WELWYN HATFIELD BOROUGH COUNCIL – DEVELOPMENT MANAGEMENT
DELEGATED REPORT

APPLICATION No:	S6/2012/1113/AD
APPLICATION Site:	Ramada Hotel, St Albans Road West

This application seeks advertisement consent for retention of 11 non-illuminated signs (5 x 'Tariff 'Pole Signs, 5 x 'Have you Paid' Pole Signs and 1 x 'Pay Here' Pole Sign)

Ramada Hatfield Car Park Sign Types

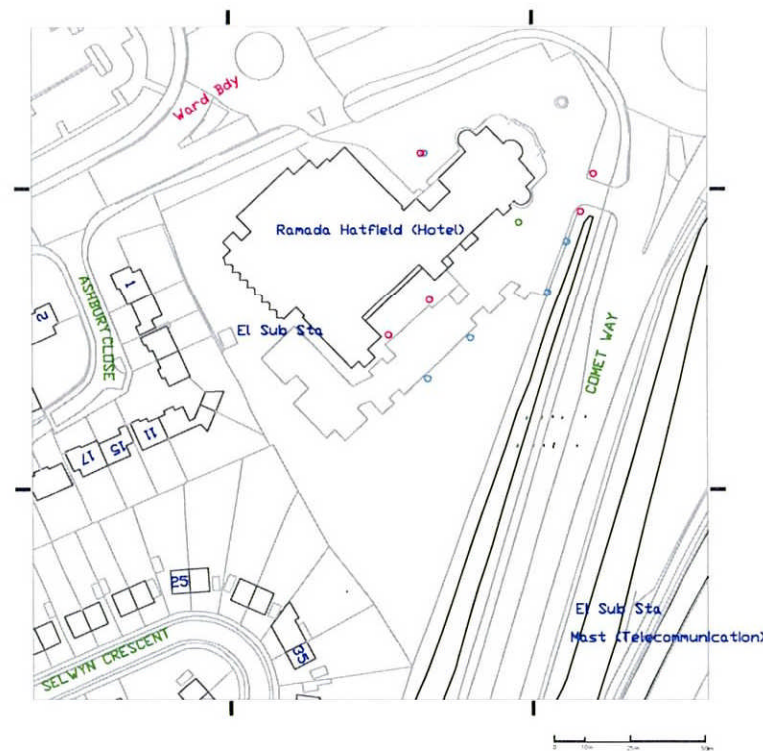
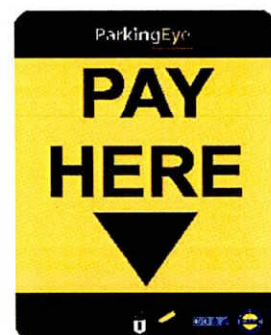
The proposed free standing signs, by virtue of their location, number, design and size have had a detrimental impact on the character and appearance of the Listed Building and its setting. The cluttered appearance detracts from the architectural qualities of the building and the visual amenity of the street scene. The proposal conflicts with National Planning Policy Framework, Policy D1 and D2 of the Welwyn Hatfield District Plan 2005 and the requirements of the Supplementary Design Guidance (Statement of Council Policy).

1. The proposed free standing signs, by virtue of their number, design, size and location within a prominent frontage area have had a negative impact on the character and appearance of the Listed Building and its setting. The cumulative impact of a large number of signs has resulted in undue visual clutter which in turn detracts from the architectural qualities of the building and the visual amenity of the street scene contrary to the National Planning Policy Framework and Policy D1 of the Welwyn Hatfield District Plan 2005 and the requirements of the Supplementary Design Guidance (Statement of Council Policy).

Ramada Hatfield Signage Plan Scale 1:2500

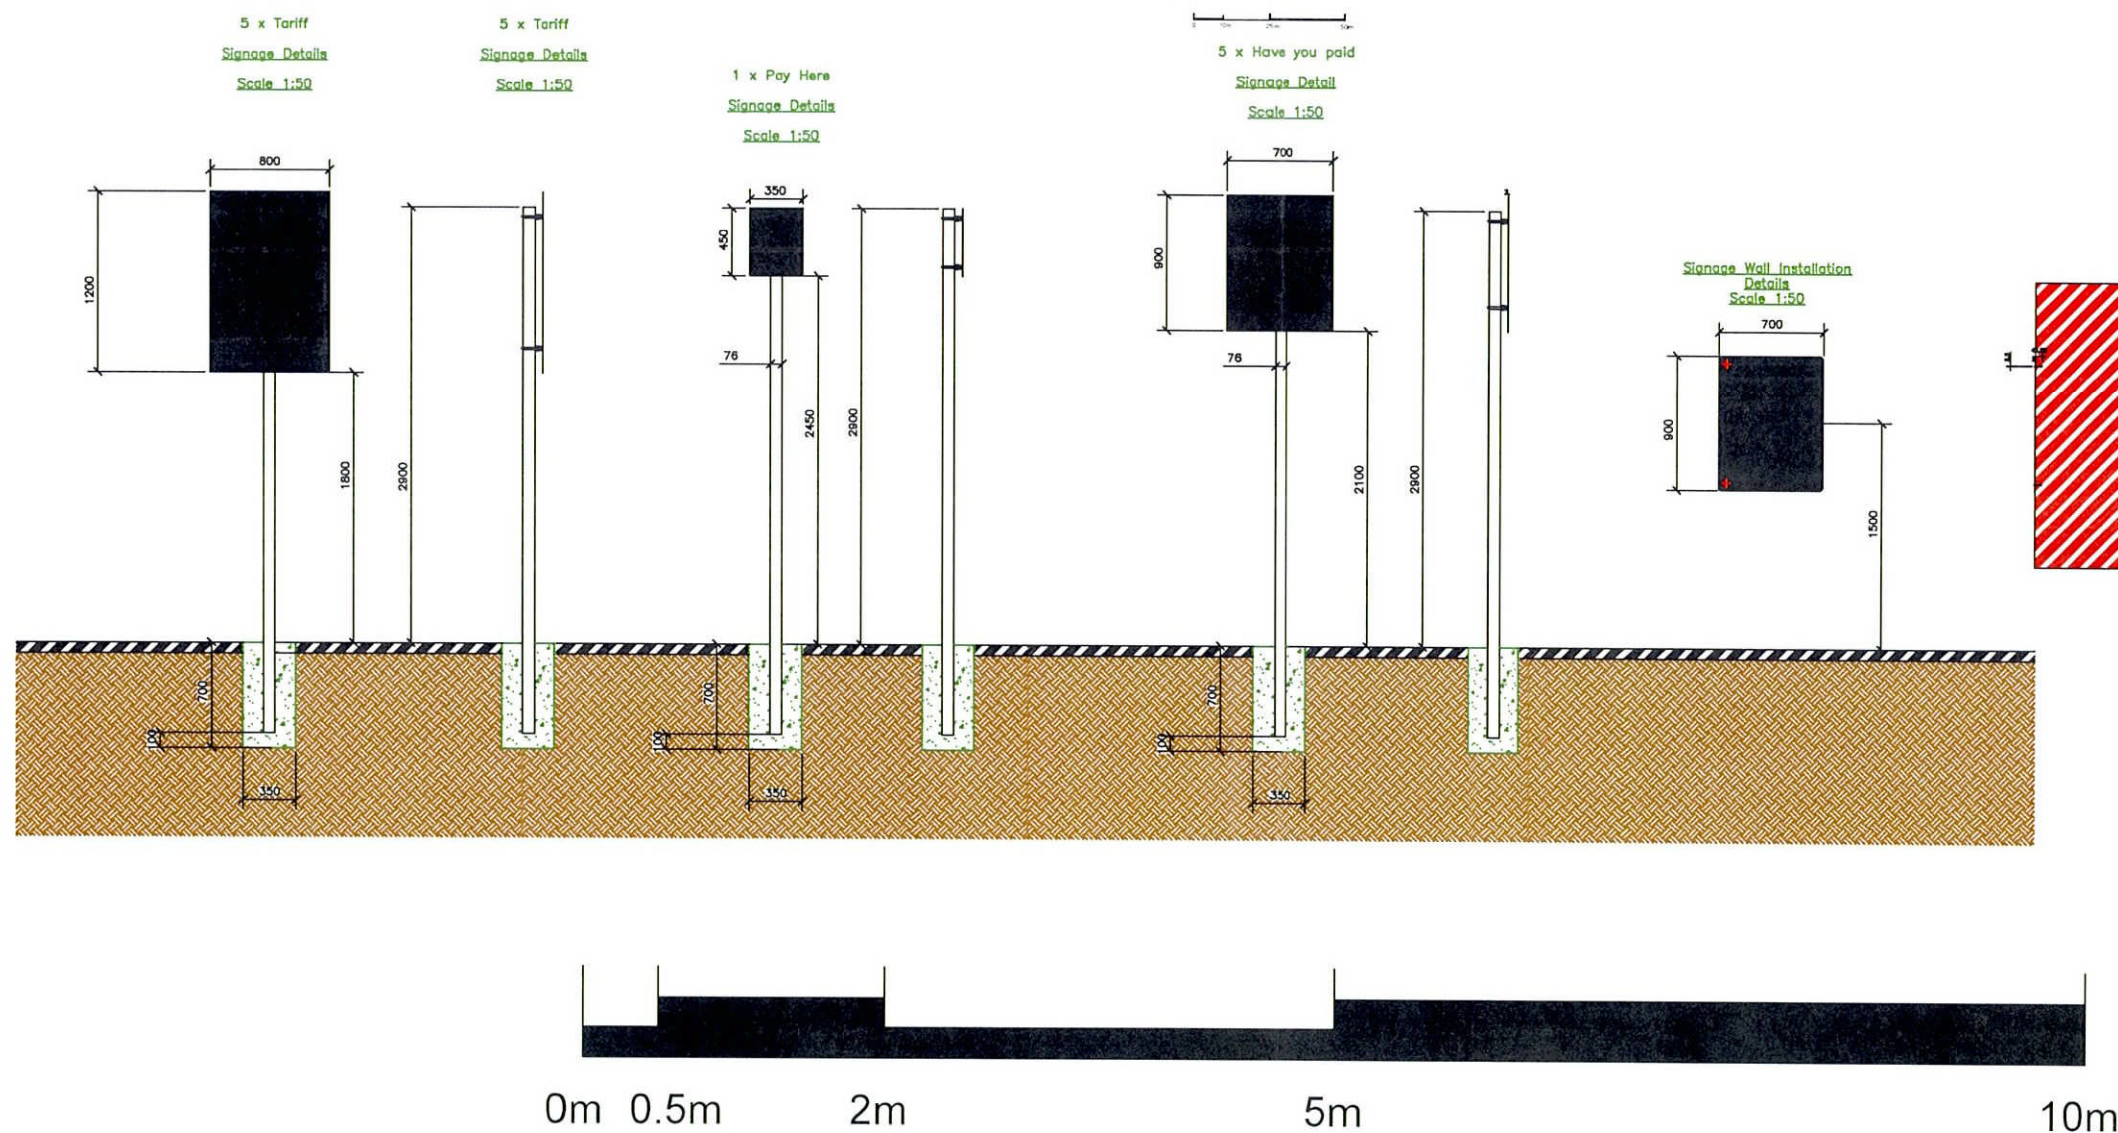
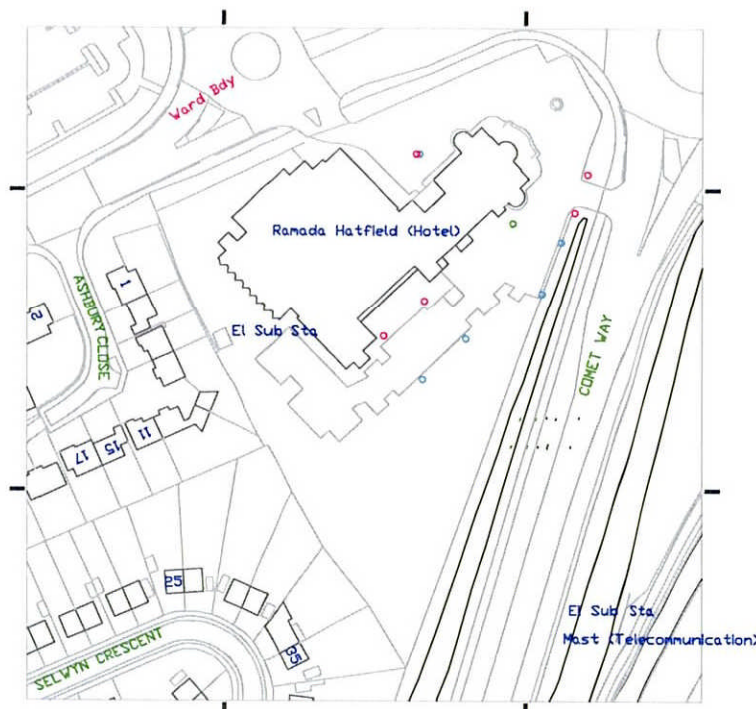
The 11 signs which are the subject of this application are already displayed on site. All of the signs are attached to poles which are situated at various locations around the hotel car park. The car park wraps around the front of the building and is highly visible from St Albans Road West and Comet Way. Although in this case the proposed signs are freestanding, it is still appropriate to consider their design and how well they relate the character of the application building.

Whilst the impact of each individual sign is not severe, it is the total amount of signage proposed, in addition to existing signage, which cumulatively creates undue visual clutter which in turn detracts from the character of the building and the visual amenity of the area. The visual impact of the signage is more prevalent as a result of their bright yellow background, which is clearly intended to be visually prominent and contrasting. In this location, however, the signs represent an obtrusive form of development that detracts from the character of the Listed Building and its setting.
